Our Ref: FG/56/19/HH
Your Ref:

Town & Country Planning Act 1990 (as amended)
Town & Country Planning (Development Management Procedure) (England) Order 2015
Application for Planning Permission for Works or Extension to a Dwelling

Development Ramps to front and rear elevation, proposed tarmac drive

Location 51 Ferring Lane Ferring

Proposed Plan

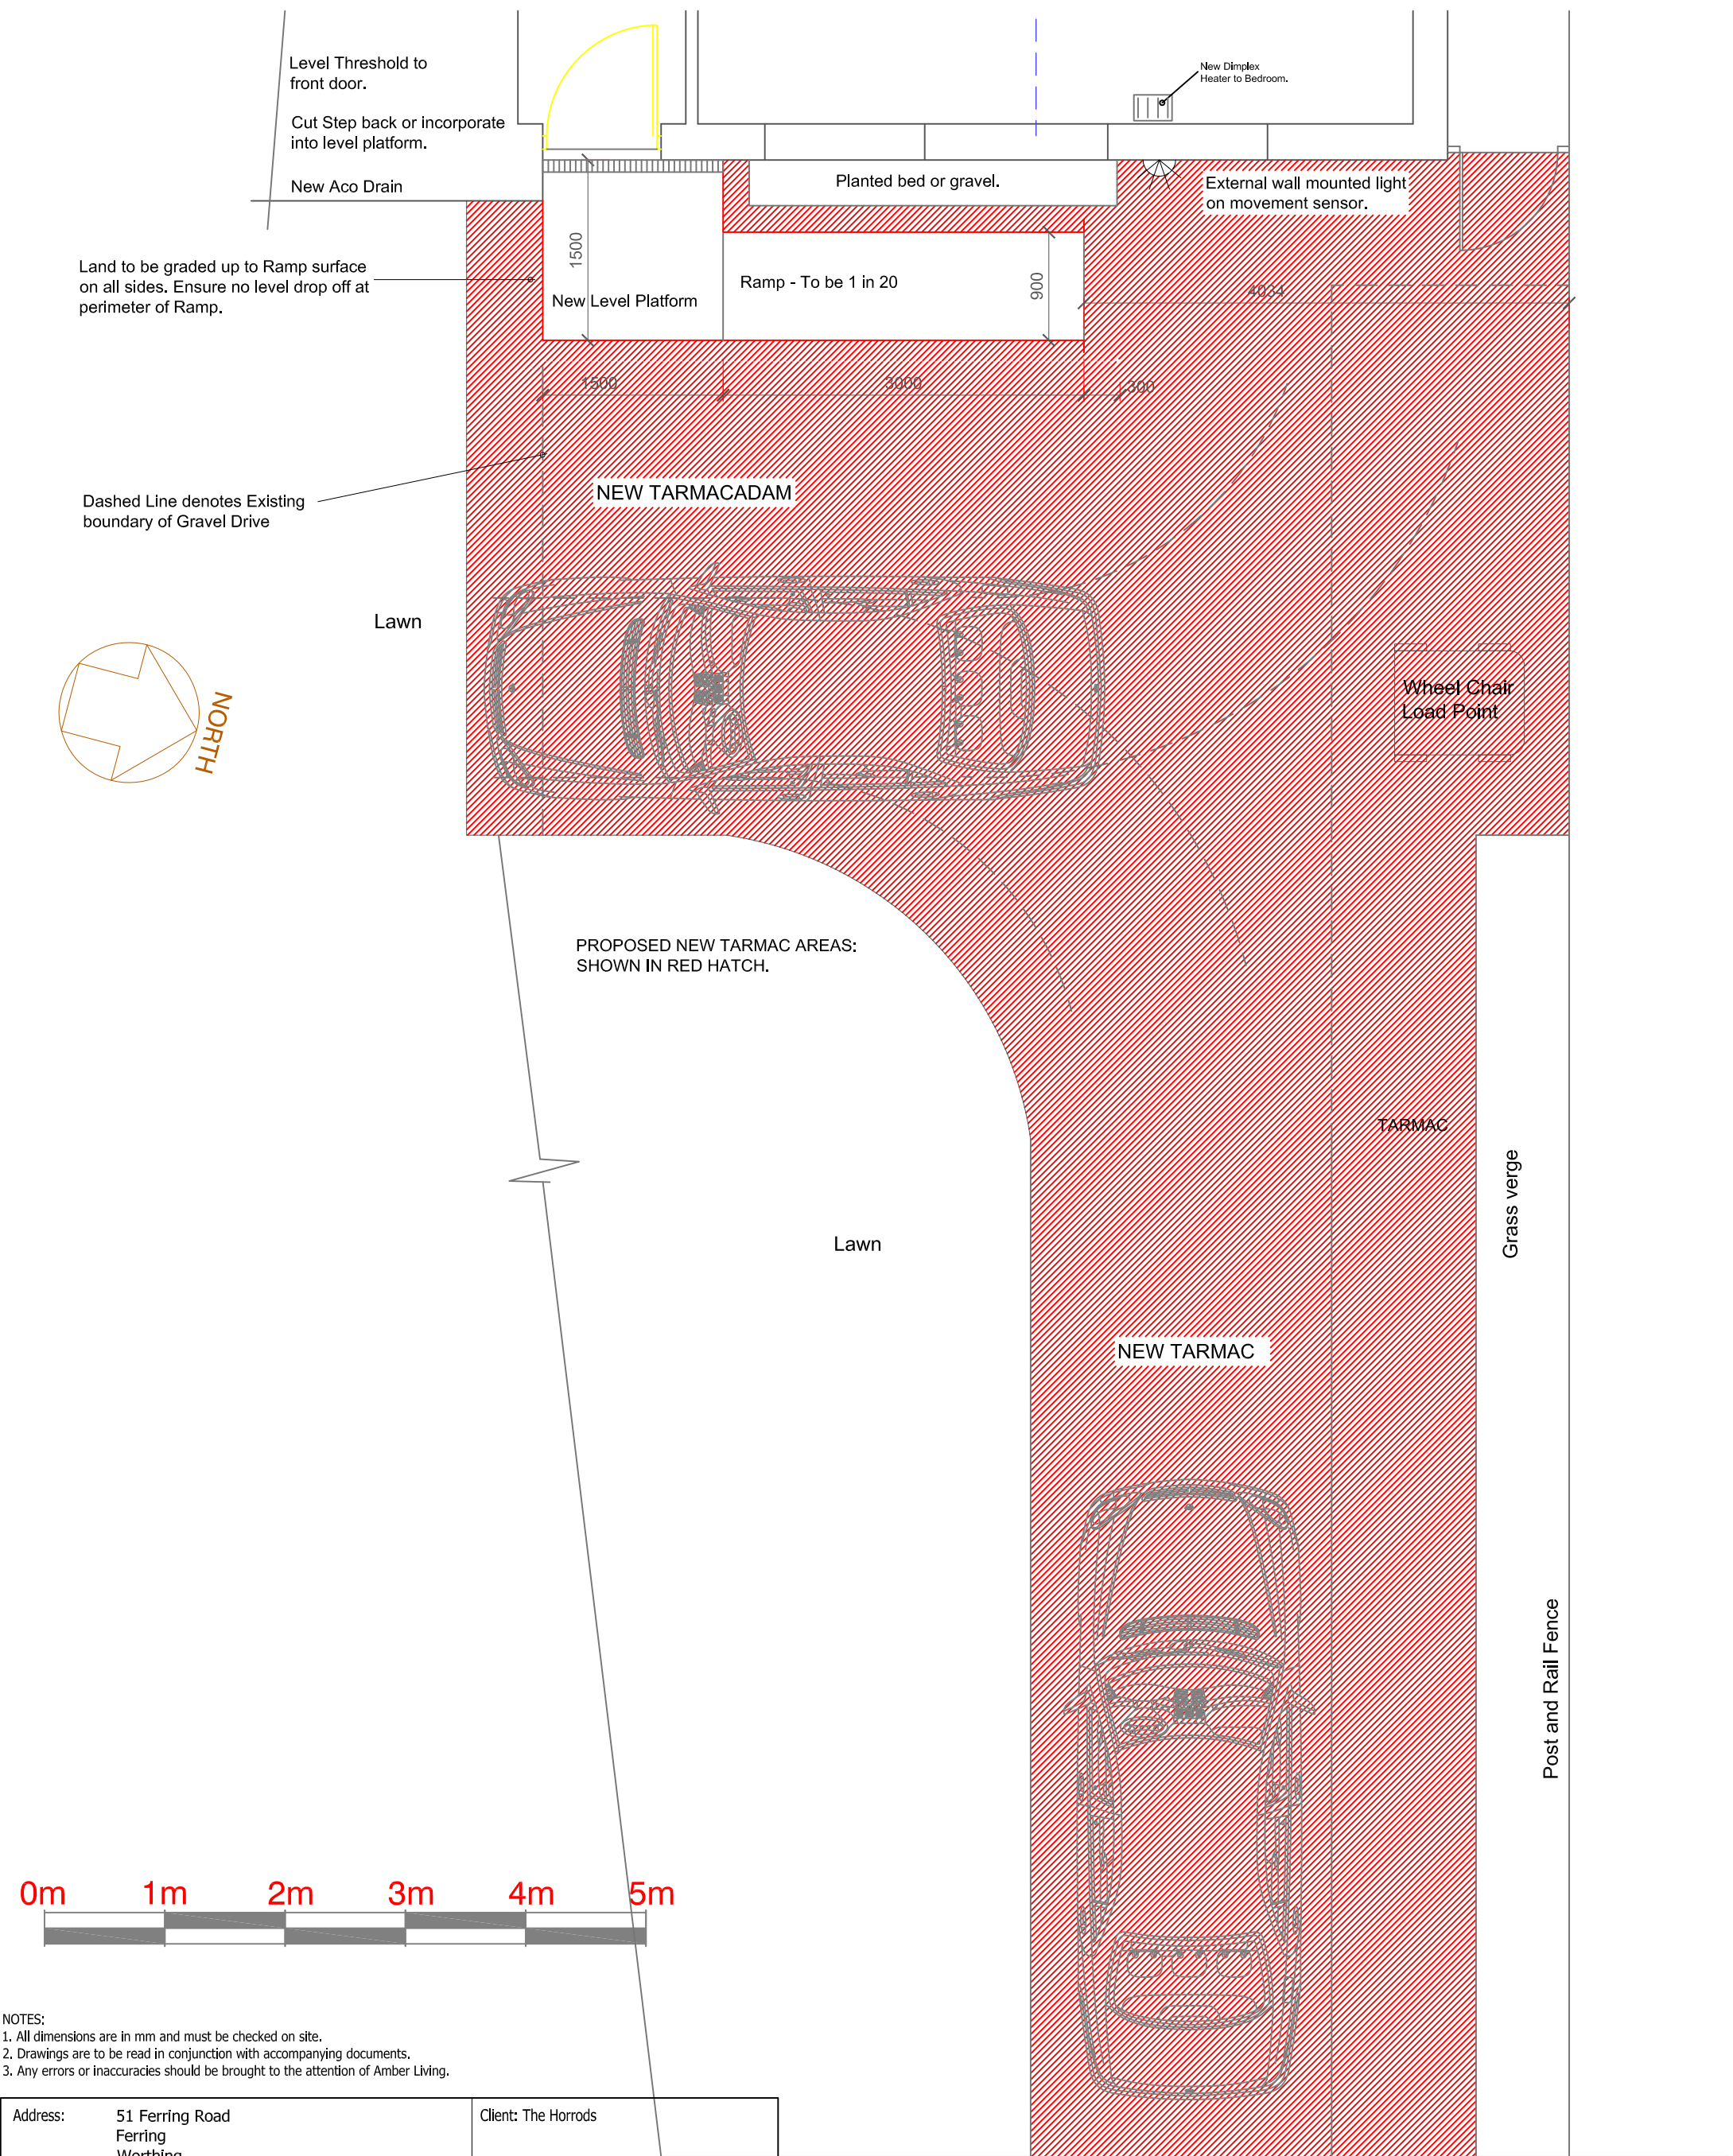
Please show the proposed ramps on the block plan and annotate the dimensions from the ramps to the site boundaries.

Proposed land grading
FRONT ELEVATION - Proposed

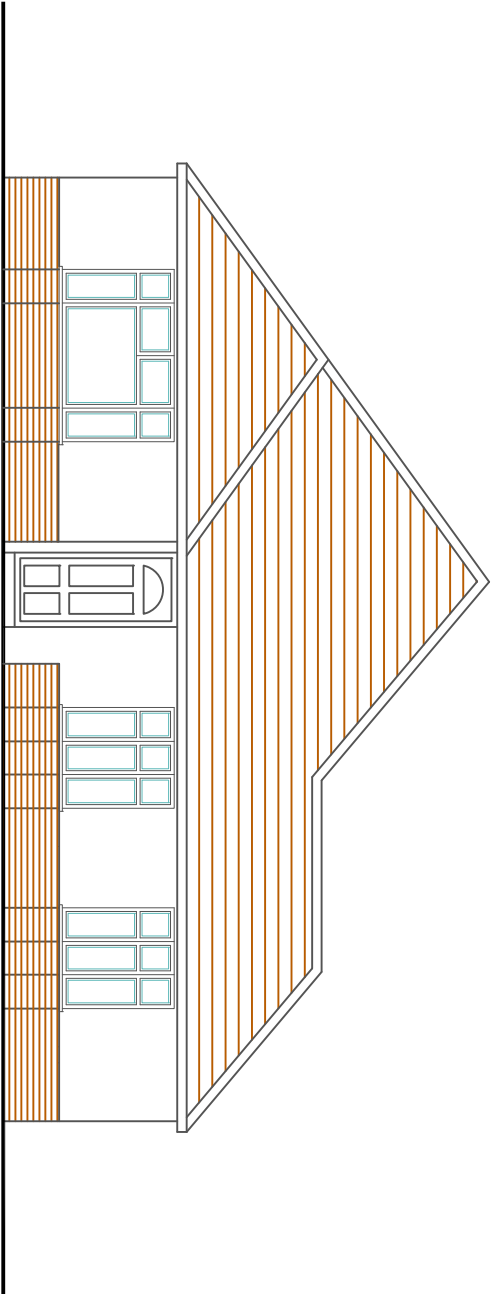
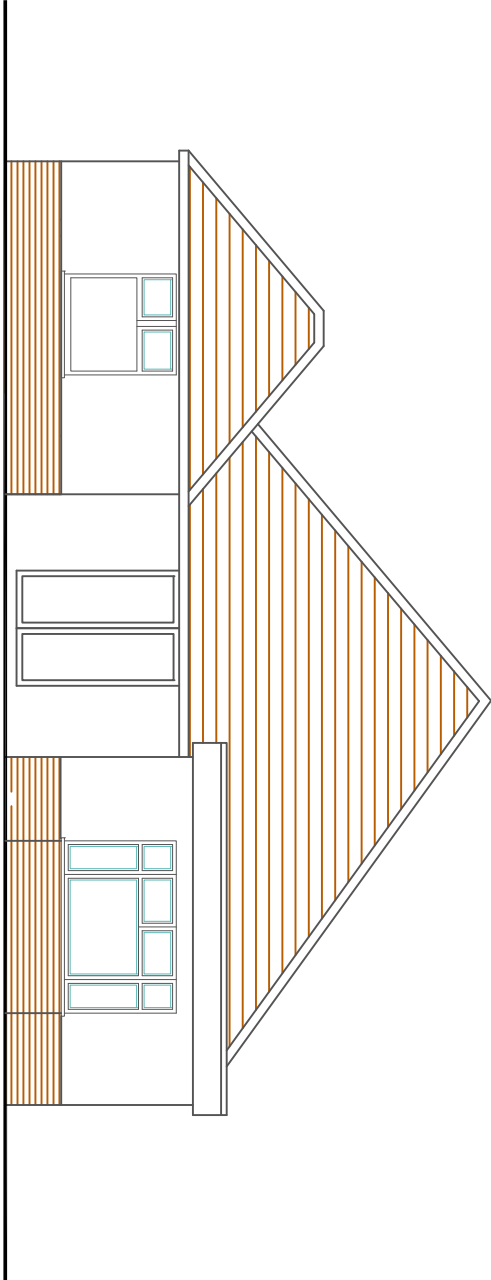
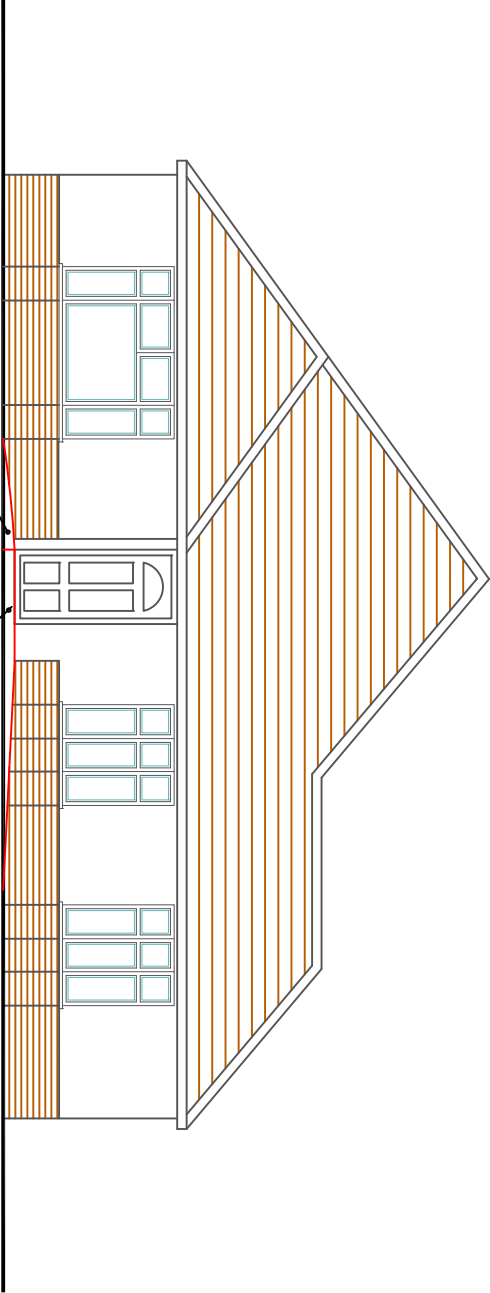
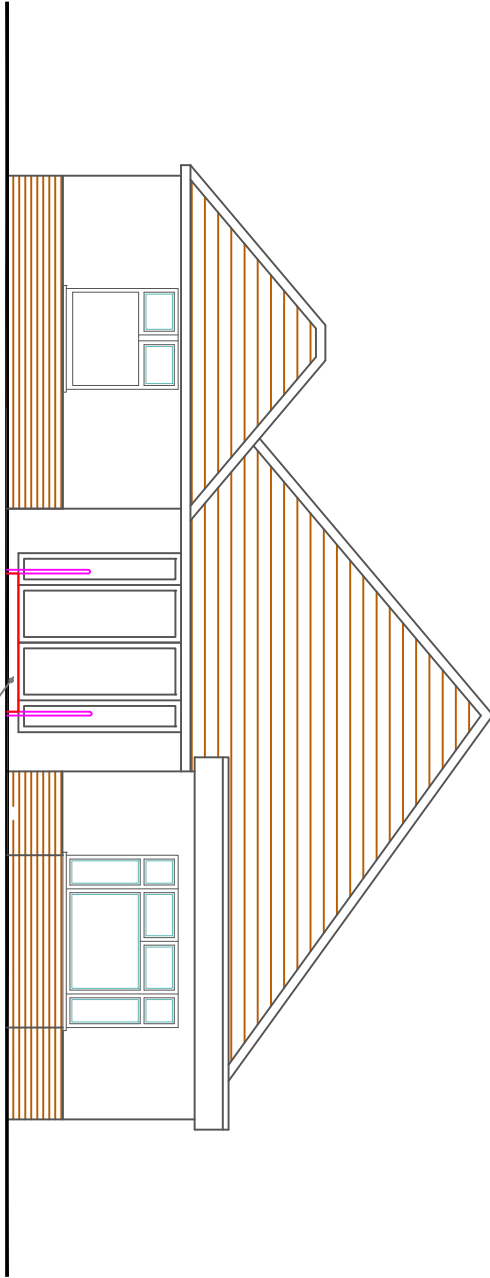
Please submit 1 electronic or 3 paper copies of clearly labelled proposed elevations at a scale of 1:50 or 1:100. Further details can be found in the National Validation Requirements.
